RE: Response to Request for Additional Information – 42 Honey Suckle Drive, Newcastle – SSD 10378

This letter is submitted to the Department of Planning, Industry, and Environment (DPIE) in response to the Request for Additional Information (RAI) issued on 3 December 2020, relating to SSD 10378 located at 42 Honeysuckle Drive, Newcastle.

Status	DD		
Scale	1 : 150	@ A1	
Drawn	Author	Checked	Checker
Project No.	s12109		
Plot Date	10/05/2018 3:17:10 PM		
Plot File	42HONEYSUCKLEDRIE_ARCH		
Drawing no.	AD.03.101	Revision	2

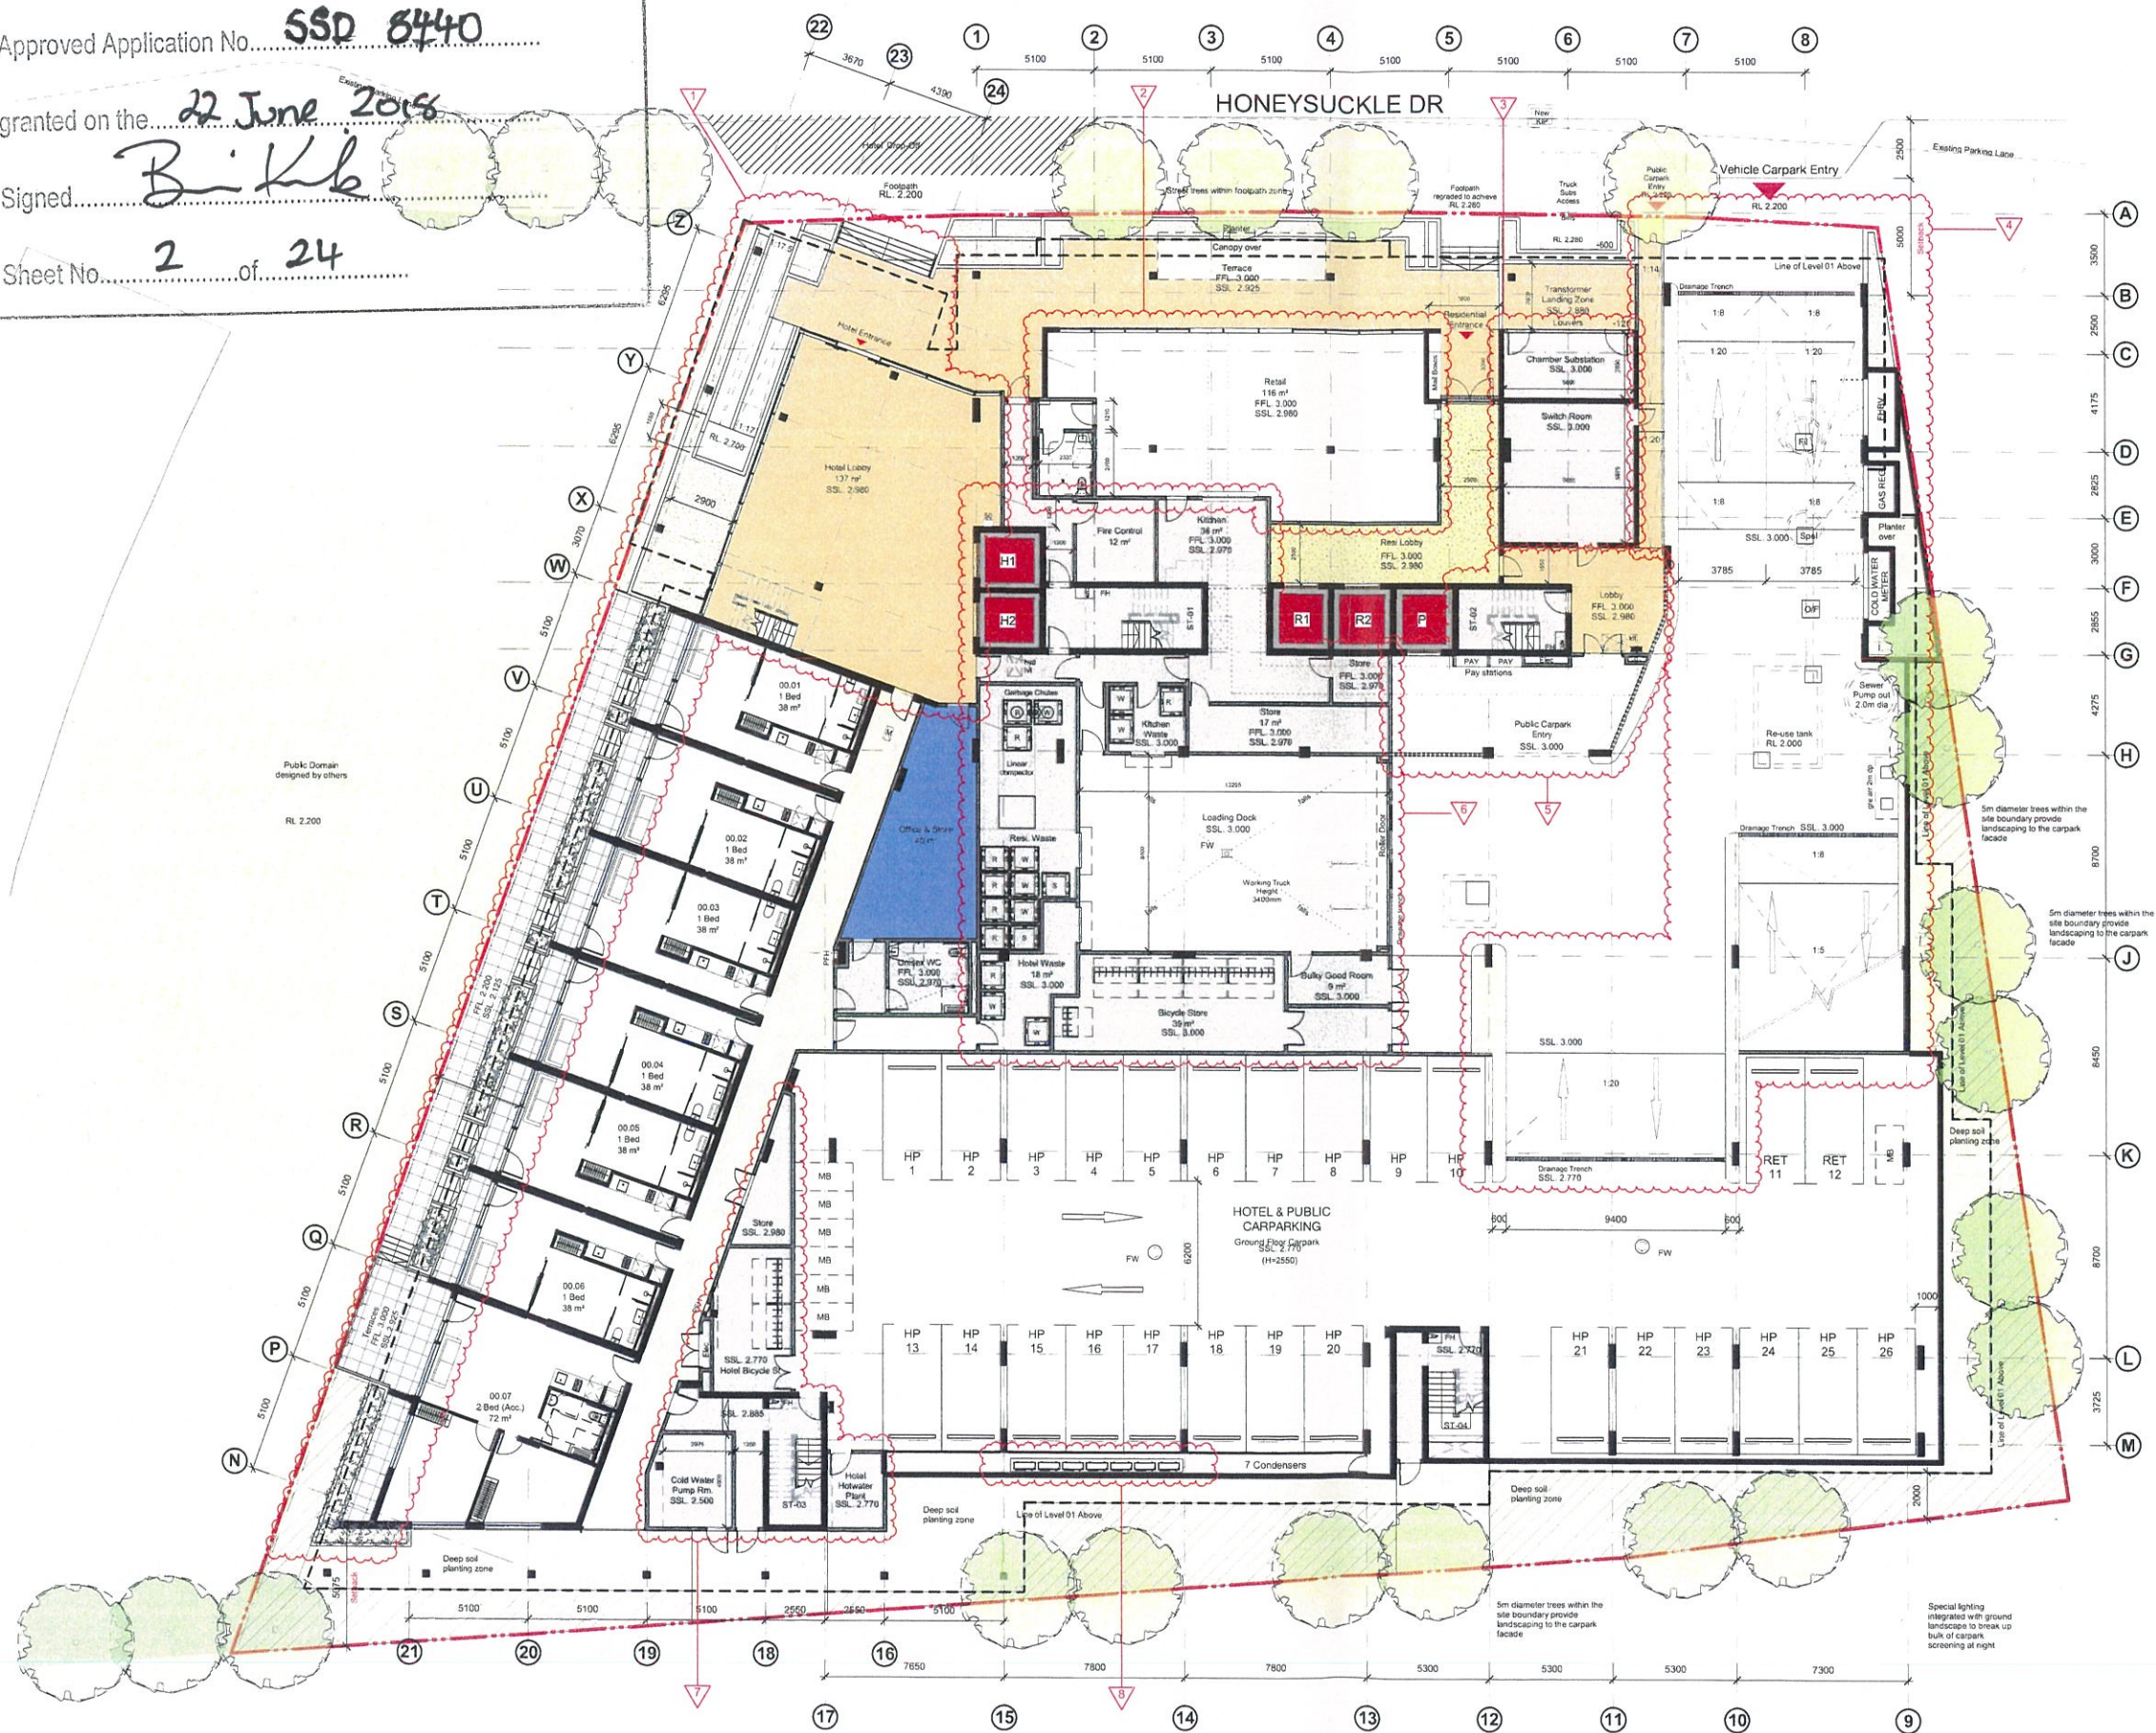
1. Amended plans showing the ground floor access a minimum height of 4.5m required for a medium rigid vehicle in accordance with AS2890.2.

Under SSD 8440 (22 June 2018) The Department of Planning, Industry, and Environment (and Newcastle City Council) previously approved a loading dock with a working height of 3.400m and a vehicular height clearance of 3.585m, (refer to Appendix B, drawings AD03.101-2 and Sk014-1 respectively). At the time of that approval all parties were satisfied that waste collection via private vehicles could be accommodated.

Bates Smart have reviewed the plans and obtaining the required 4.5m is unattainable. To provide for the clearance will increase the height of the building and also affect the flood levels. The design as presented, with 4.3m access, has proceeded as DOMA and associated consultants are confident that the proposal can be serviced under the current scheme. An email provided by Remondis has confirmed they can service the proposal via the basement waste collection area, refer to Appendix A, this has been assessed and reiterated by SLR traffic consultants in their amended TIA submitted with the previous response to submissions.

The application is therefore not seeking to be compliant with the Australian Standard for MRV vehicles and does not need to be 4.5m but has also demonstrated that a range of larger vehicles that do not typically exceed 3.8m can still use the loading dock as proposed, providing an acceptable level of flexibility.
